June 2, 2017

City of Albuquerque
Planning Department
Current Planning Section

Re: Environmental Planning Commission
Project#: 1011188, case #17EPC-40007 May 11 – Site Development Plan for Building Permit

EXISTING SITE & UTILITY PLAN

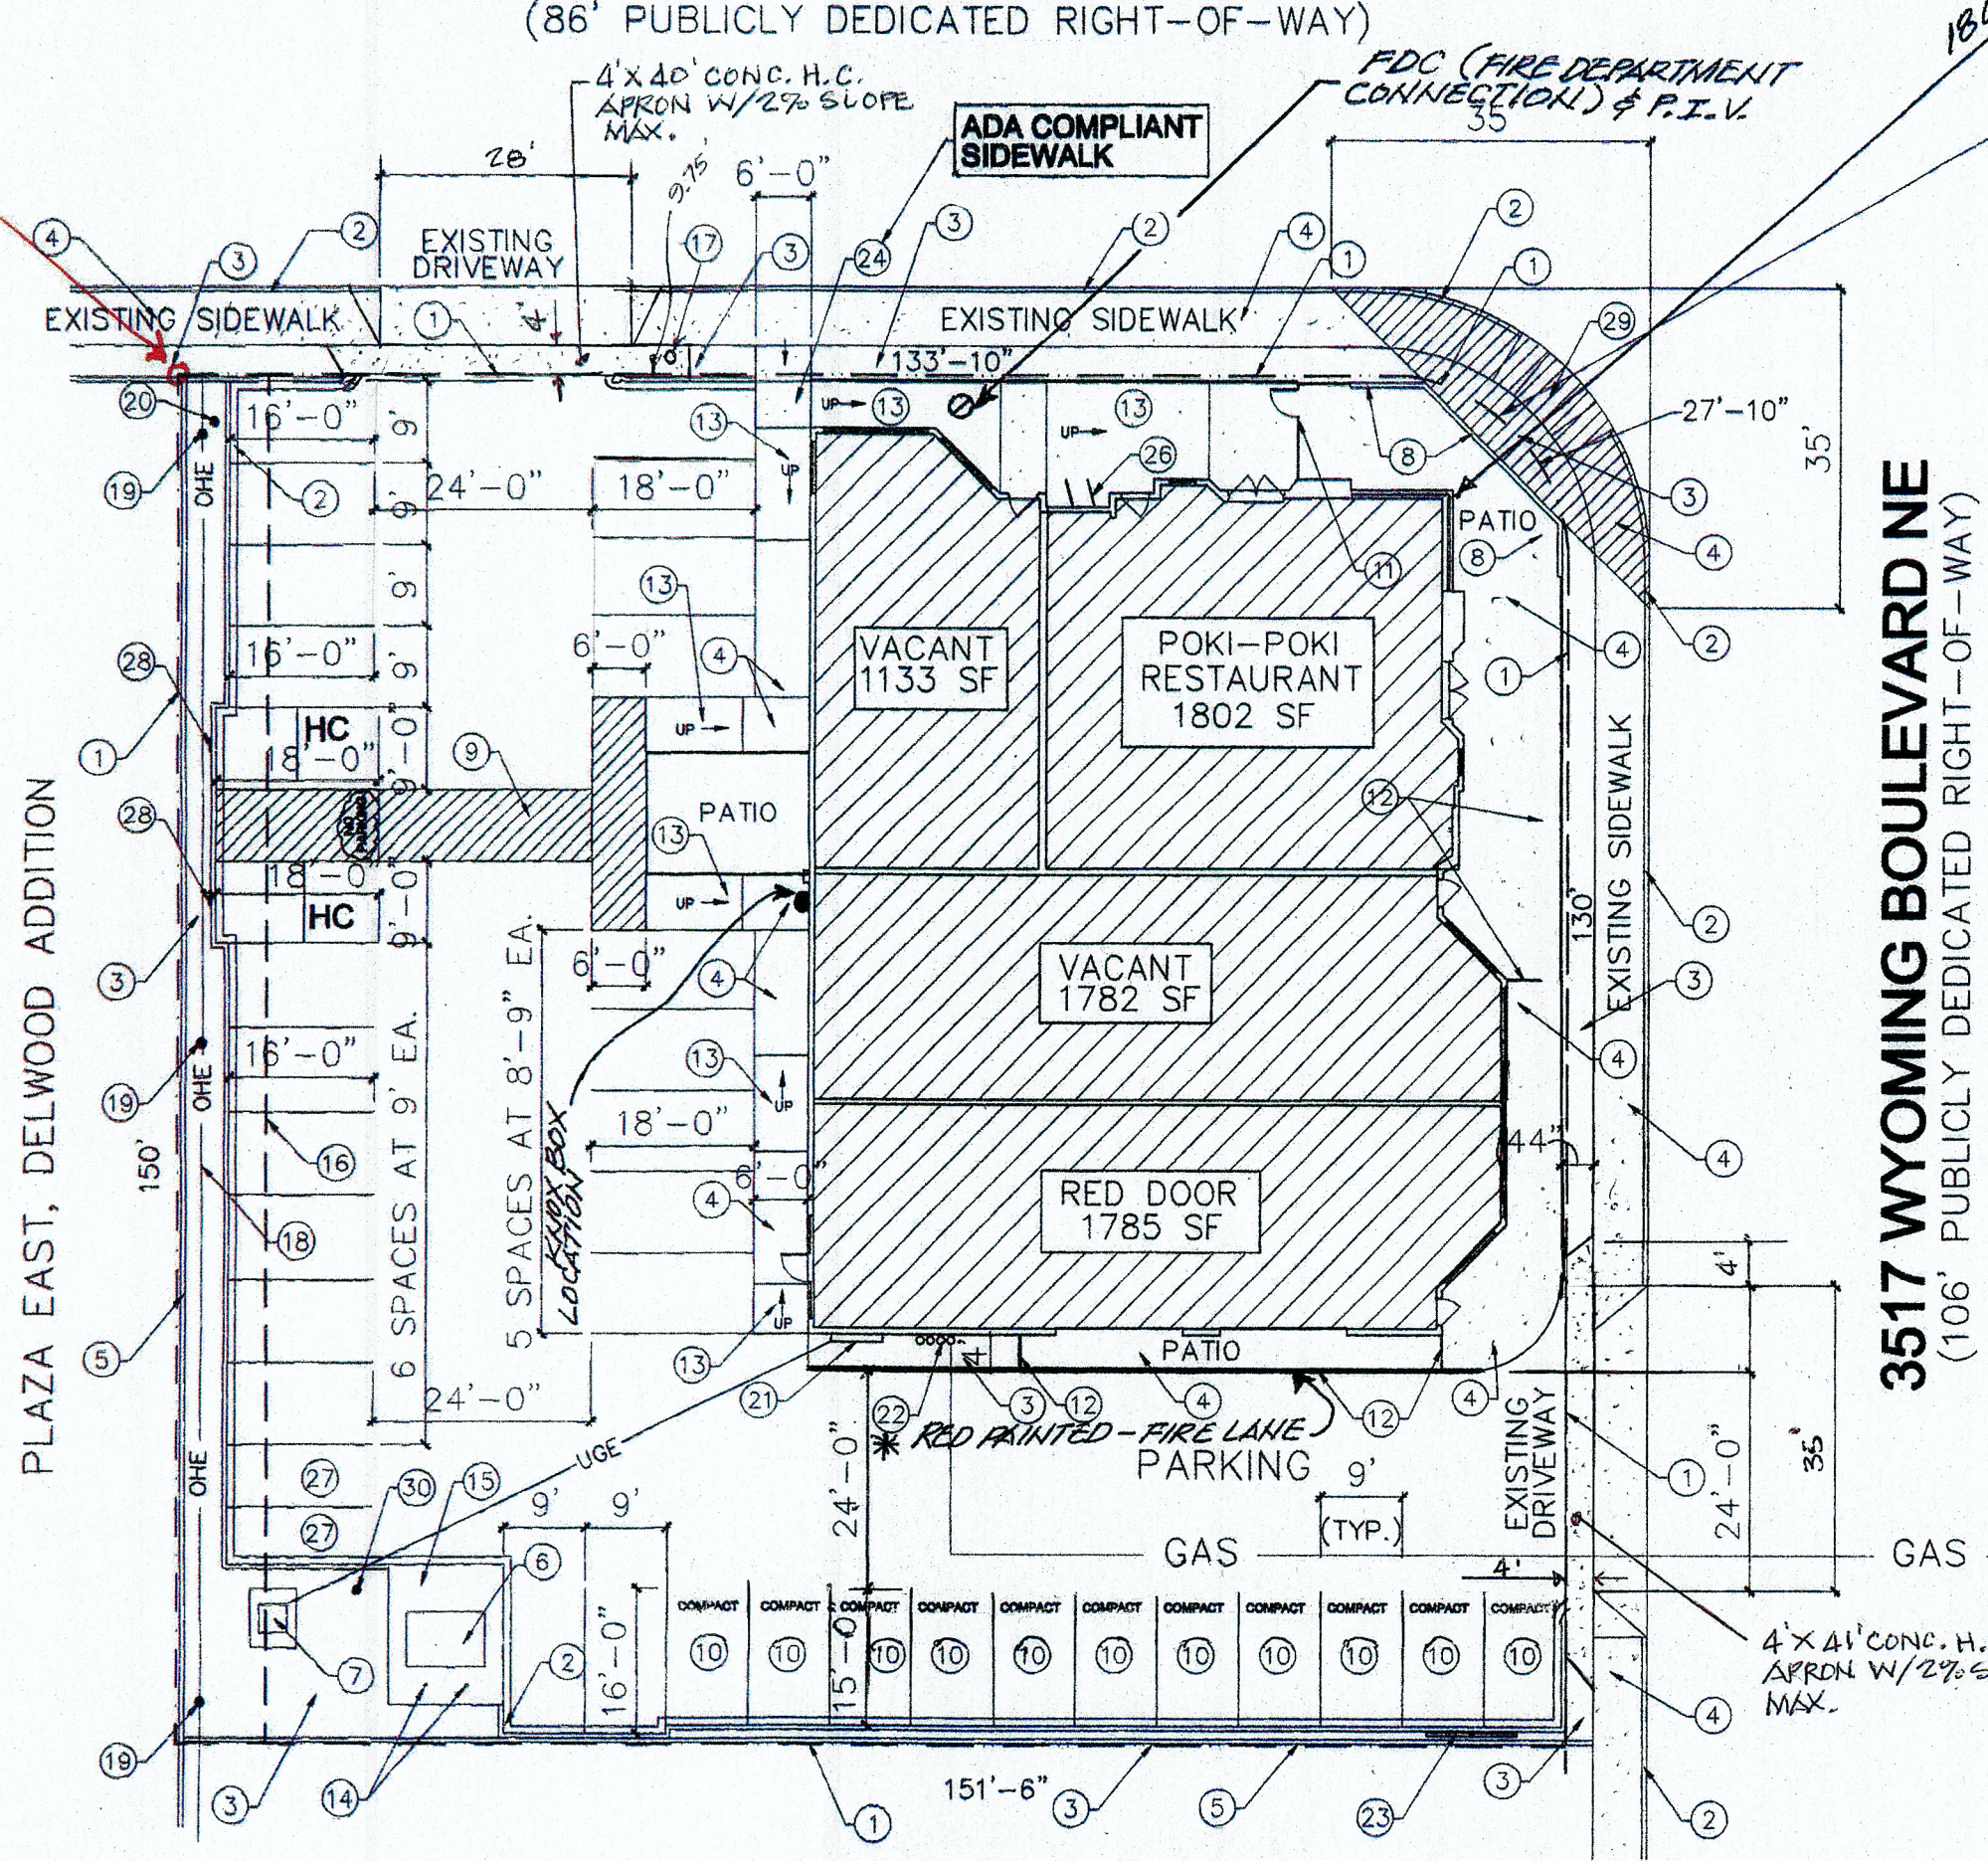
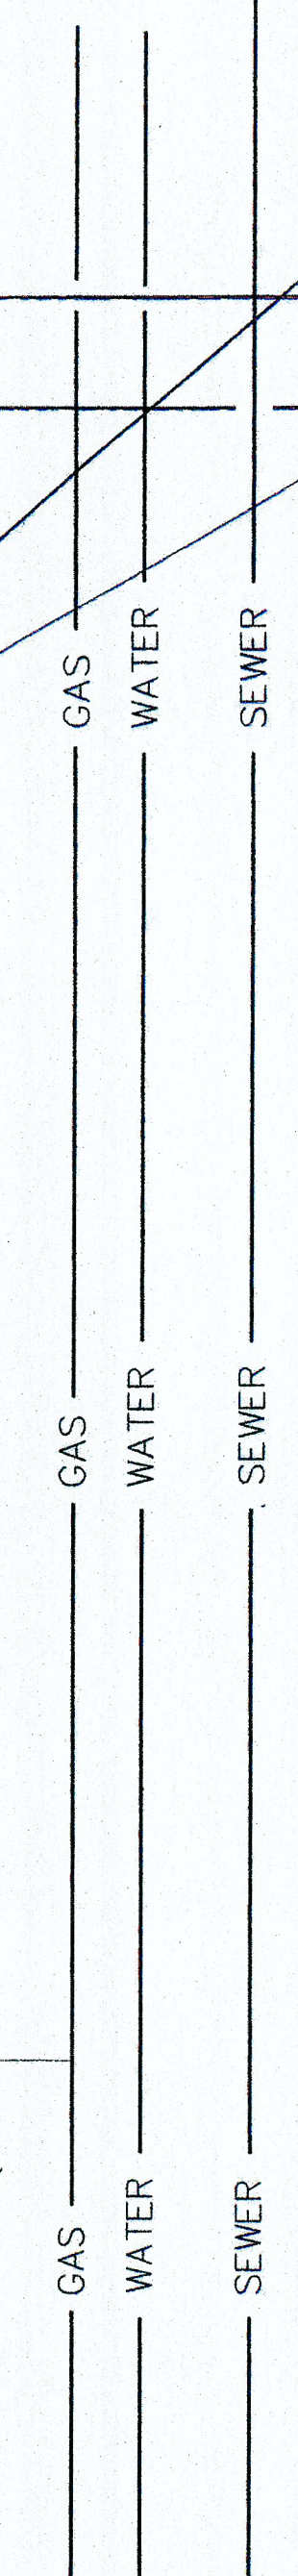
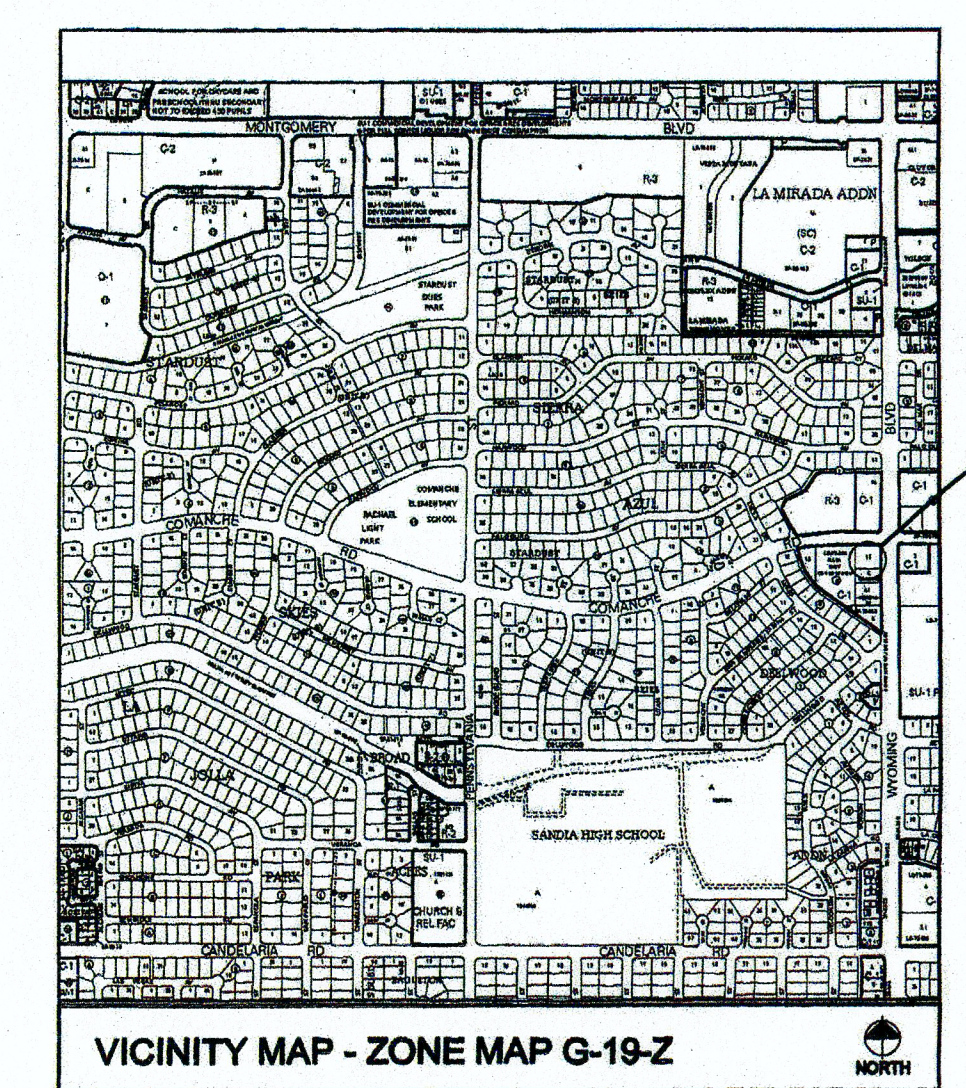
Comment Number 4: A pole mounted light fixture has been added on the site plan by the refuse bin. See keyed note number 30.

Comment Number 19: All compact parking spaces are labeled “COMPACT”.

Comment Number 20: The following note has been added to the clear site triangle:
“Landscape and signage will not interfere with clear site requirements. Therefore, signs, walls, trees, and shrubbery between 3 and 8 feet tall (as measured from gutter pan) will not be acceptable in this area”.

1 H.C. PARKING SIGN
A1 NOT TO SCALE

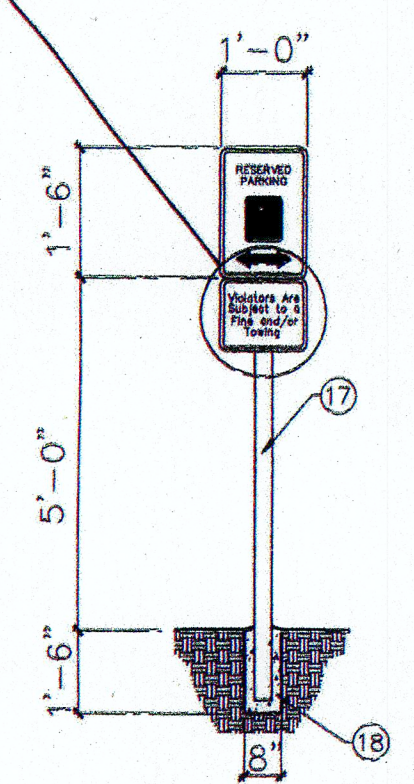
Comment Number 17: Detail 1/A1 has an enlarged detail indicating that “Violators Are Subject to a fine and/or towing”.
